From: Maria Tomalova
Sent: 19 June 2019 10:05
To: Planning.Responses
Subject: FW: FP/274/18/PL, 10 Felpham Gardens
Attachments: Prop Park Elevation 2.pdf; Prop Plot Plan 125 2.pdf; Prop Street Elevation 1.pdf; Garage Detail Unit 2.pdf; Prop Elevations Unit 2 Rev C.pdf

From: Maria Tomalova [REDACTED]
Sent: 14 May 2019 12:47
To: Tim Rodway | Rodway Planning [REDACTED]
Subject: FP/274/18/PL, 10 Felpham Gardens

With reference to our recent phone conversation please find below some suggestion for an amendment of your proposal:

PROPOSED ELEVATIONS
UNIT 2

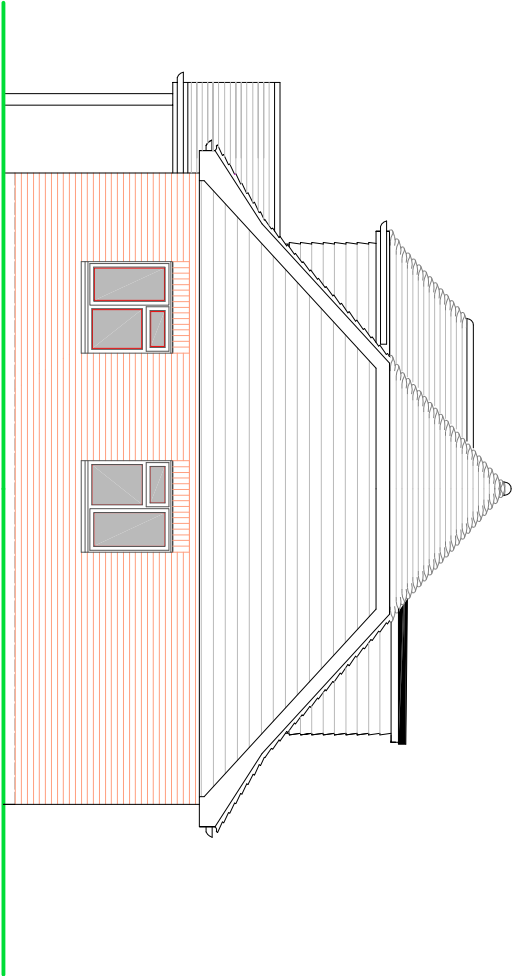
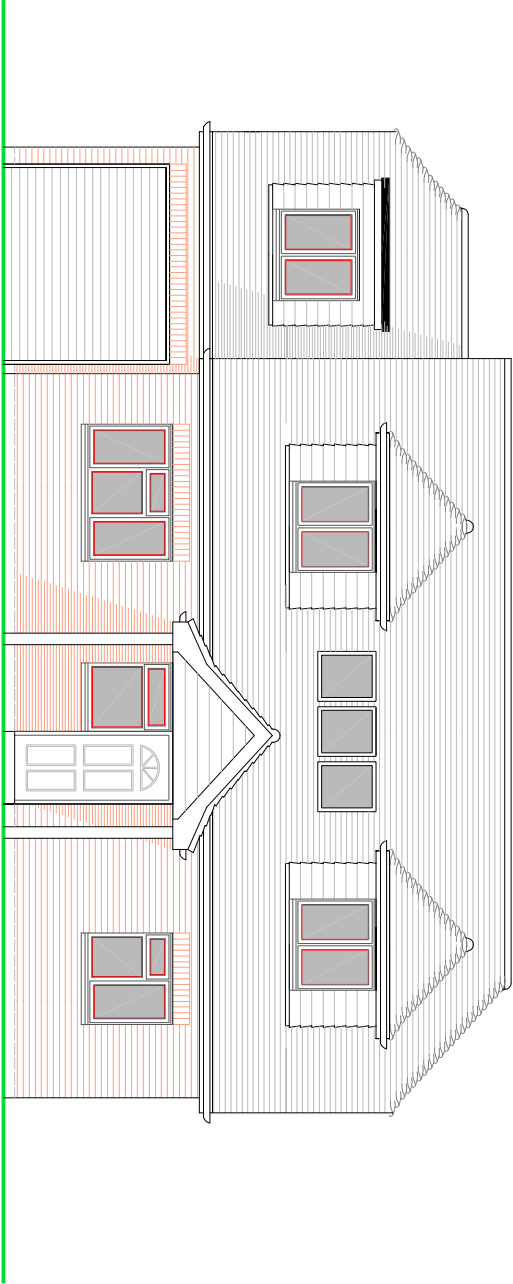
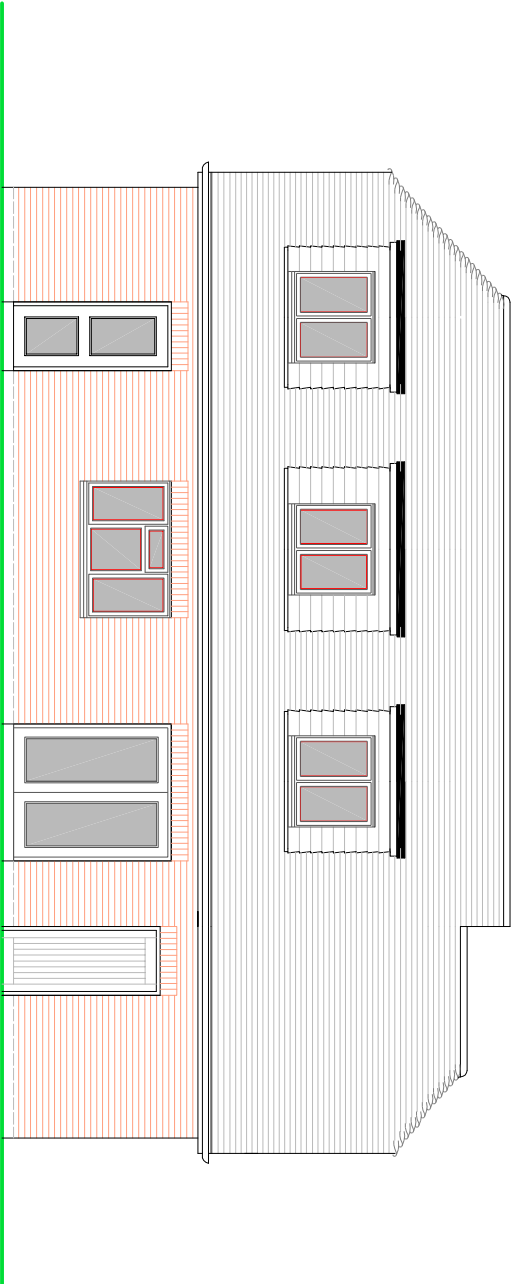
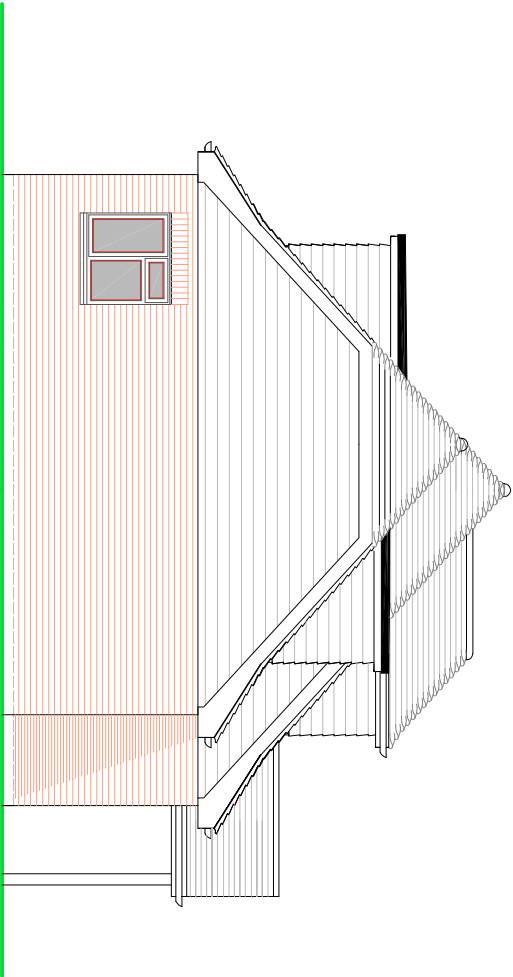
- Lower the ridge of the roof; one level in this particular case would be desirable
- Unit 1 is proposed aligned with the existing house No 8 Felpham Gardens as such it would not affect substantially the residential amenity of this property.
- However the proposed Unit 2 of the same shape and scale as Unit 1 would be obscuring the outlook from the rear of No 8 and would be an overbearing structure

(12.5m deep, 6.7m high), entirely closing the view to the south and within the winter time when the sun is low, from the sun-light.

Suggestion: proposed Unit 2 should be reduced considerably (the height in the between of the proposed Unit 1 and an existing bungalows to the east) to be

acceptable without affecting the amenity and prospect of inhabitants of No8

Probably you can reduce the width of Unit 2 by re-positioning the garage where the cycle storage is proposed with a direct access to it.

In summary, and in line with your advice, Unit 2 has been reduced to a single storey dwelling. Unit 2's garage has been repositioned, in line with your recommendations. We can advise that the gross internal floor area of the new bungalow is 84 m2, which comfortably meets the National Space Standards requirement for a 3-bed single storey dwelling.
